Appeal Decision

Appeal Ref: APP/R5510/W/18/3198847

51 Wieland Road, Northwood HA6 3QX

- The appeal is made under section 78 of the Town and Country Planning Act 1990 against a refusal to grant planning permission.
 - The appeal is made by Mr Nadeem Boghani against the decision of the Council of the London Borough of Hillingdon.
 - The application Ref 17990/APP/2017/3191, dated 1 September 2017, was refused by notice dated 4 January 2018.
 - The development proposed is replacement dwelling.
-

1832.02.06

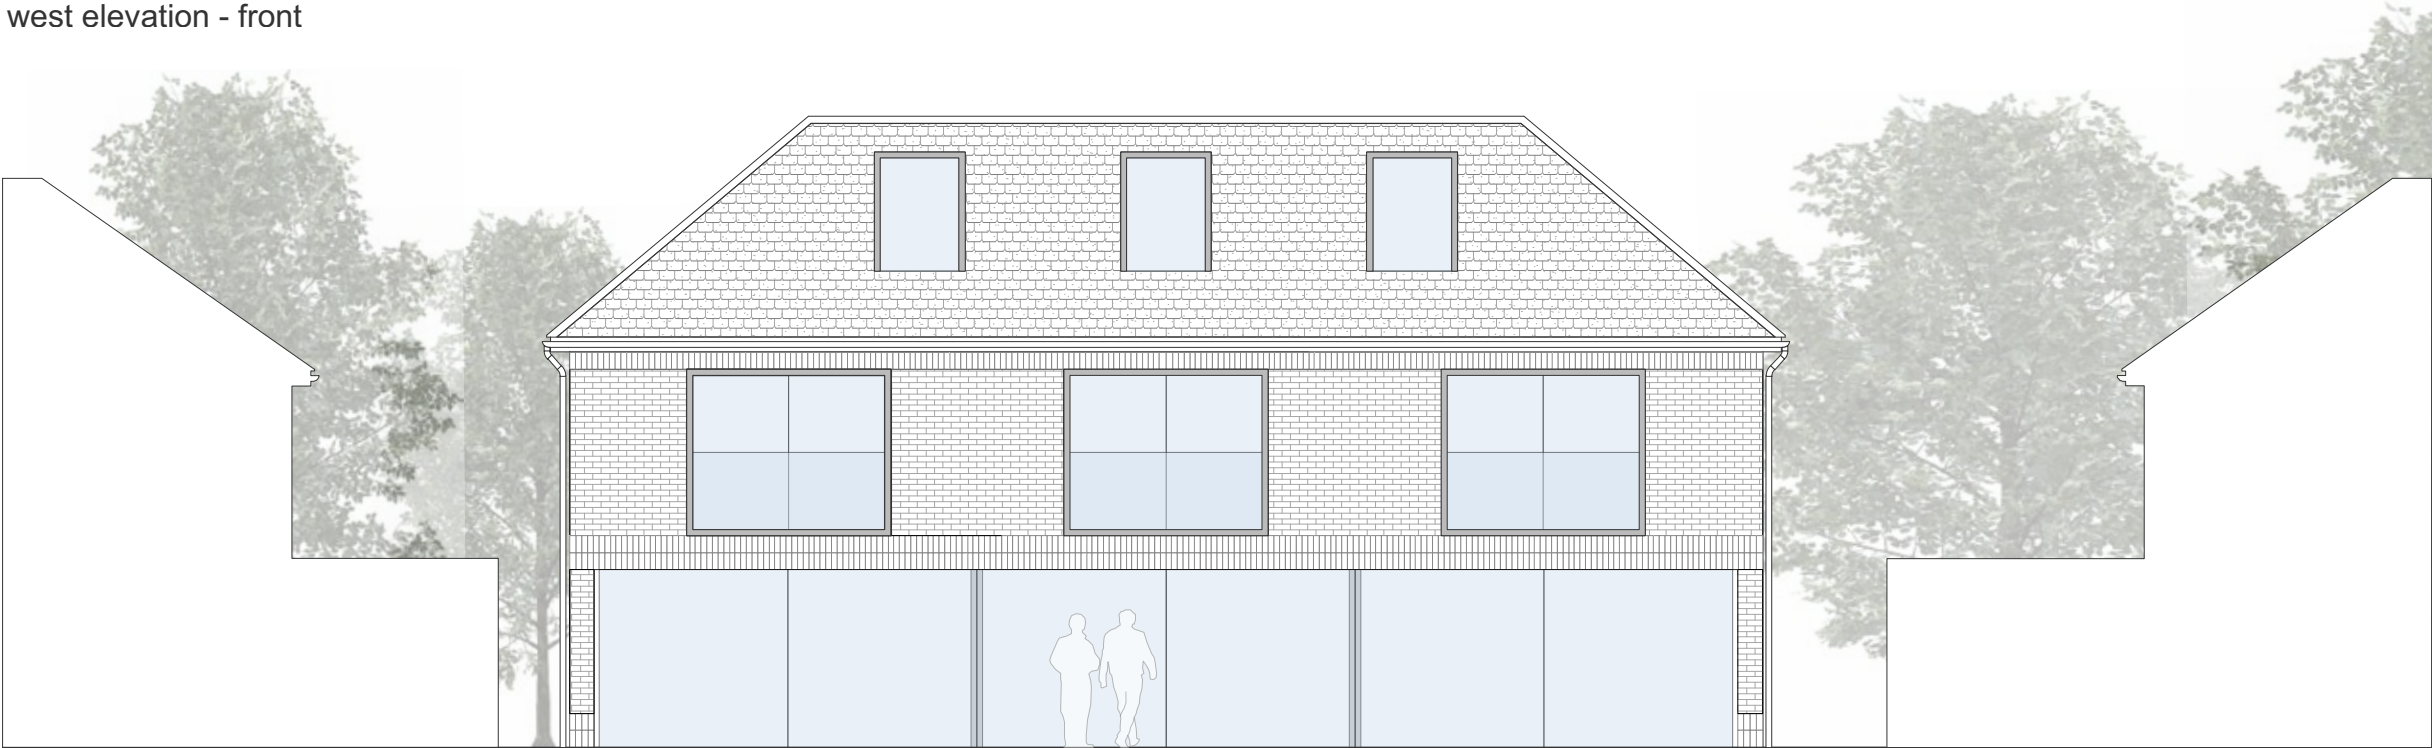
8. Concerns have been raised that the proposed crown roof would appear bulky and dominant; however, the proposed dwelling would be a broadly similar height as the existing and surrounding properties and the distance from the eaves of the roof to the ridge would also be similar. In addition, I noted several crown roofs in the vicinity. Furthermore, the roof would mimic the predominant hipped roof form of surrounding properties when viewed from the front. These factors weigh in favour of the proposal.

10. Whilst the height of the proposal would be comparable to the existing dwelling; the overall width when taken together with the crown roof and wide windows would result in a dwelling with a squat appearance. Furthermore, it would present a bland and symmetrical façade to the street and the large blocks of glazing would result in a higher void to solid ratio than is typical of the area. As a result, the facade would not reflect that of surrounding properties which generally have a more vertical emphasis with asymmetrical features and a higher solid to void ratio with glazing broken up by glazing bars. Moreover, the lack of visual relief contrasts markedly with the interesting and detailed architectural features of surrounding properties which give light and shade to their facades. These factors weigh against the proposal.

11. On balance, whilst the mass, scale and siting are reflective of the existing and surrounding properties, I consider that the plain, robust, and symmetrical façade combined with the horizontal proportions and dominant blocks of fenestration would be in stark contrast to the animated facades of surrounding properties. The proposal would, therefore, represent an incongruous addition at odds with the character and appearance of the area.
